3062 - Design comments/tasks to be completed/addressed

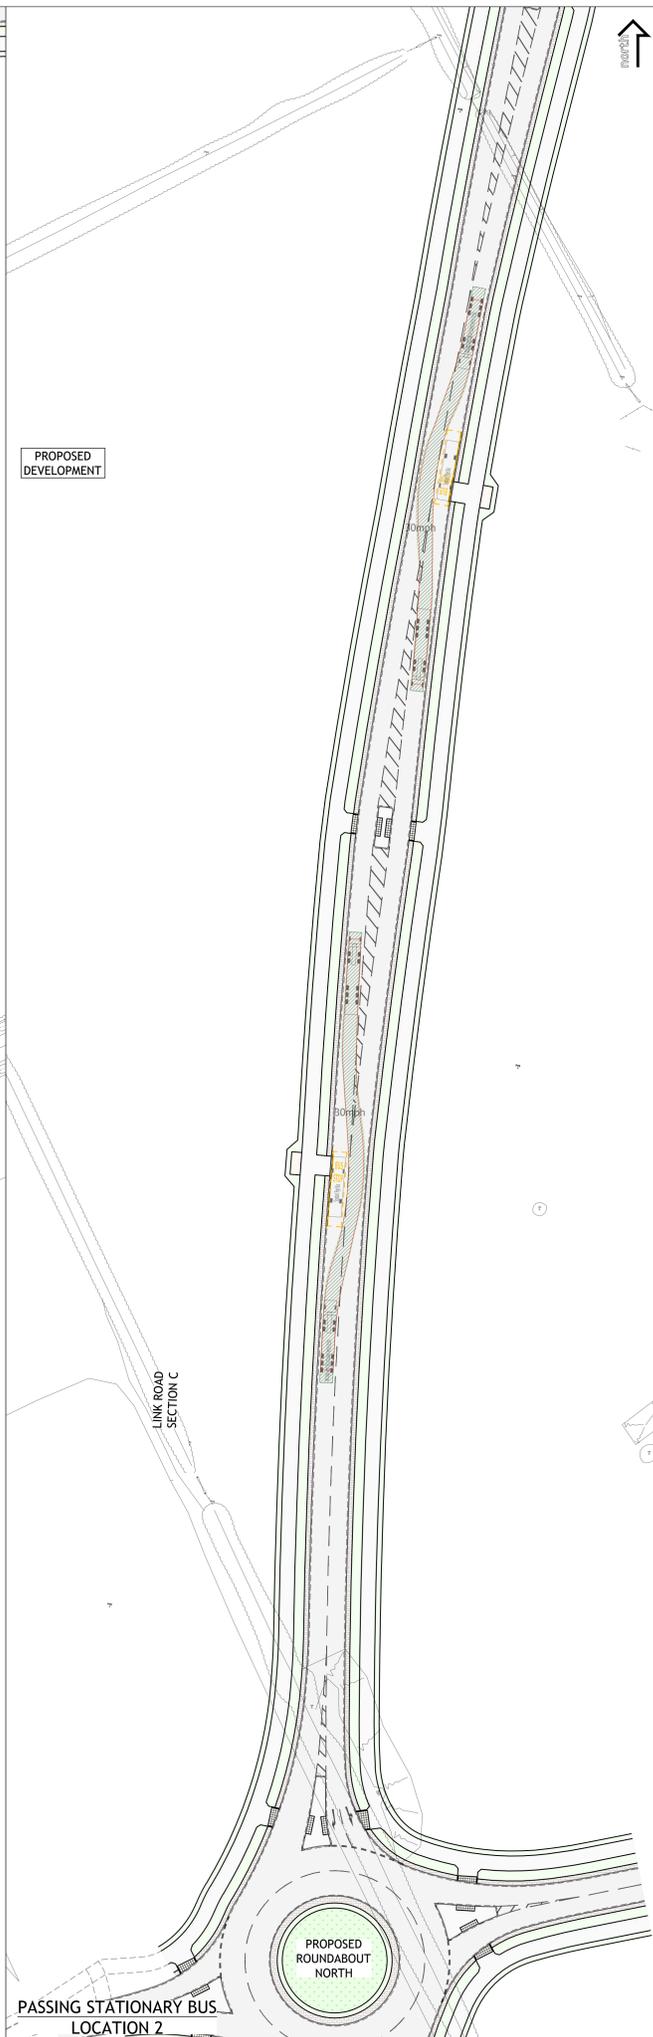
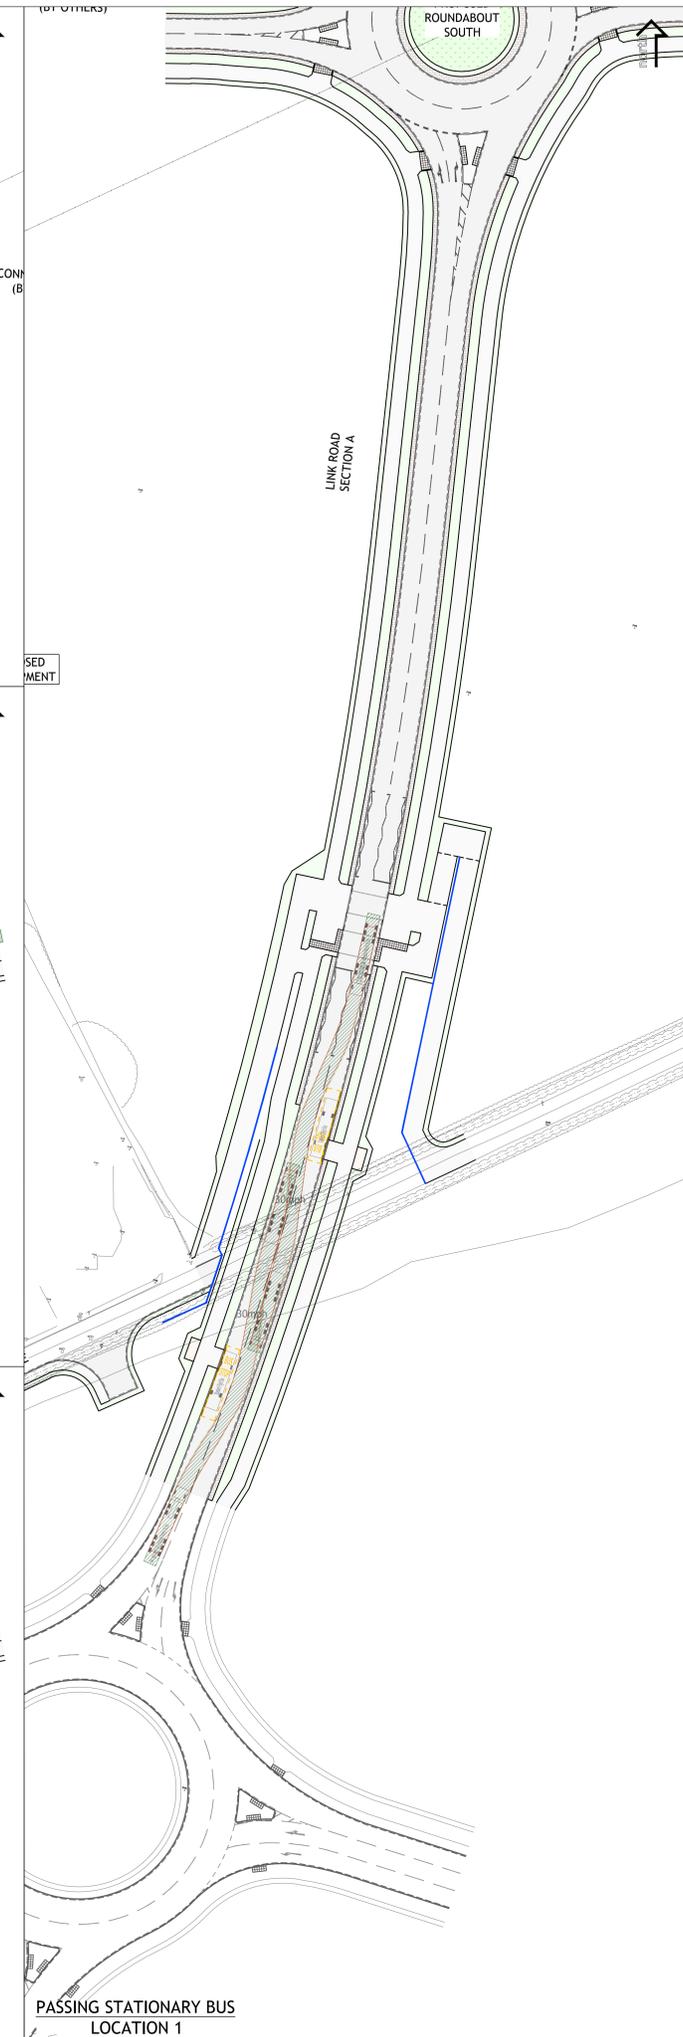
item	Comment/Task	Category	Response	Date
1	7.3m carriageway road, 1.0m hard strip (tarmac or paving), 2.0m grass verge, 3.0m shared footway/cycleway and a 1.0m strip to form the back of the adopted highway.	Cross section	New cross section arrangement applied across the proposed scheme	
2	Pegasus crossing x2	Pedestrian crossing	Pegasus crossing introduced in indicated location.	
3	Signal controlled crossing	Pedestrian crossing	Signal controlled pedestrian crossing introduced in indicated location.	
4	Tie in to current Phase 1 layout (roundabout footways)	Road/footway arrangement	Tie in to residential Phase 1 layout shown indicatively on plans.	
5	Notes on all link road plans state that the proposed link road design speed as 30mph – This is to be amended to correct Kph value as specified in DMRB CD109. It is assumed this relates to a design speed of 60kph for a 30mph speed limit. Please amend.	Design speed	Notes changed to show 60kph design speed.

18	There is no reference of selected forward design speed used on the swept path analysis plan ref 3062 100-P-011.	Swept path analysis	Tracking speeds have been added.	
19	<p>There is a requirement for both roundabout and link road swept paths to be provided at an appropriate forward design speed and in accordance with the advice contained within the Autodesk user guide / helpdesk. Speeds above 15kph are to be shown with the dynamics setting turned on to give a more realistic example of turning and other features of larger vehicles. It is acknowledged that for the movements along the link road, passing a stationary bus for example, this may not be at the full 60kph / 30mph design speed, however, it cannot be accepted that such movements will be performed at the 5mph base setting. We need to ensure that the bus stops and refuge islands within the proposed design are spaced appropriately for the required movements and speeds.</p>	Swept path analysis	Dynamic setting has been used. All forward movement speeds are greater than 15mph (24kph).
